# OFFICER REPORT

<b>Application Number:</b> S6/2005/992/FP
<b>Location:</b> 23 Tolmers Avenue, Cuffley, Potters Bar
<b>Proposal:</b> Erection of front boundary dwarf wall
<b>Planning Officer:</b> Eloise Kiernan

SITE PLAN - 1:200

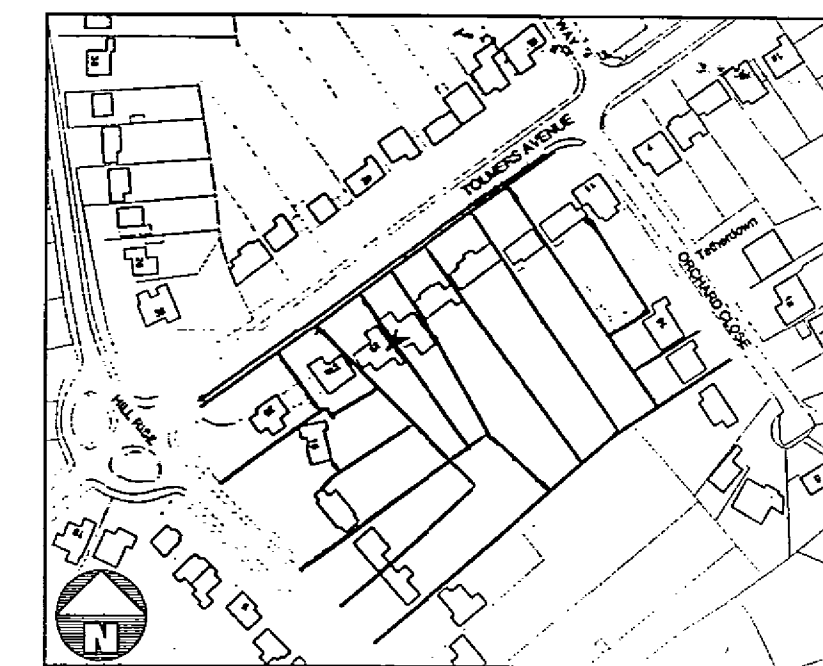
In addition, the proposal has been erected outside the curtilage of the property on land owned by Highways (Hertfordshire County Council). The front boundary to the site lays some 3 metres from the edge of the footway. Furthermore, the boundary wall is over 1 metre high in places and as such, has been erected without planning permission, therefore constitutes as unauthorized development.

FRONT BOUNDARY WALL ELEVATION - 1:50

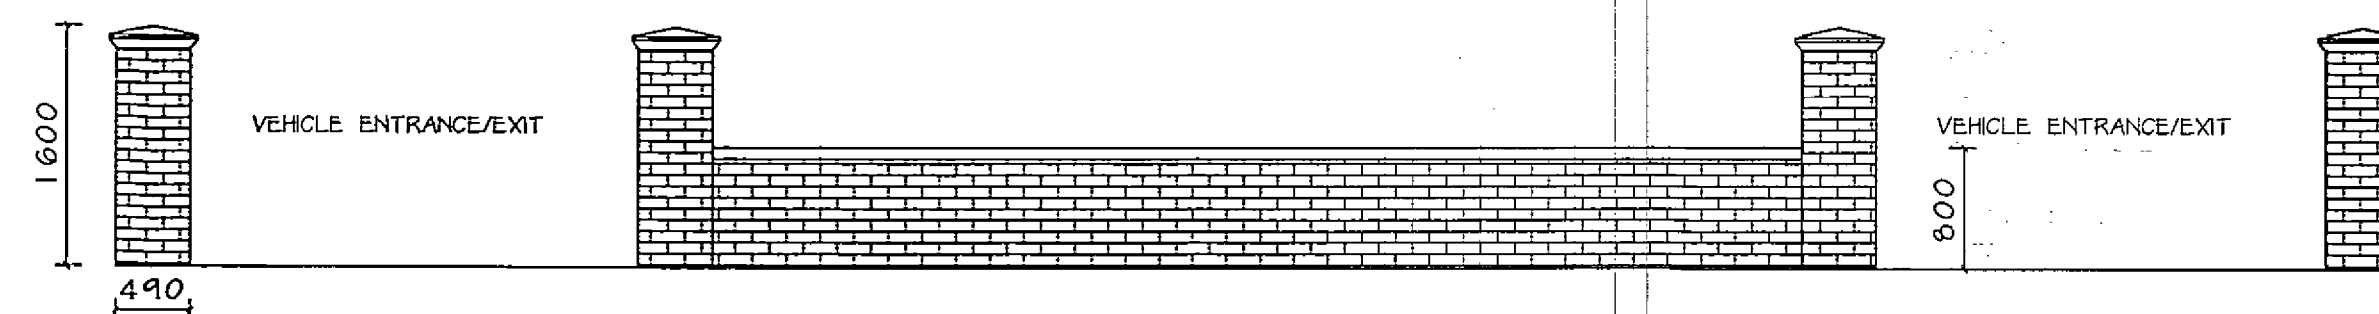
This application is retrospective and seeks permission to erect a front boundary dwarf wall with brick piers. The wall is of red brickwork to match the existing dwelling and is of 0.8 metres in height, with brick piers reaches 1.6 metres at regular intervals of a metre or so apart.

The dwarf wall is constructed of similar materials to the dwelling, which in itself enhances the dwelling. However, when considered in the context of the streetscape it is completely out of character.

Policy D1 states that the standard of design should be of a high quality and Policy D2 requires that all new development respects and relates to the character and context of the area proposed. The existing dwarf wall is not in keeping with the characteristics of the streetscape; in particular the design, which is completely unacceptable to that of the immediate neighbours. There are no similar developments within this locality of Tolmers Gardens. The development does not enhance or improve the character of the existing area.

The wall and brick piers, by reason of their design, materials, size and siting, give rise to an unduly prominent form of development, out of keeping with the generally open character of property frontages in this part of Tolmers avenue. As such the wall and brick piers are detrimental to the visual amenities of this part of Tolmers Avenue and contrary to Policies D1 and D2 of the Welwyn Hatfield District Plan 2005.
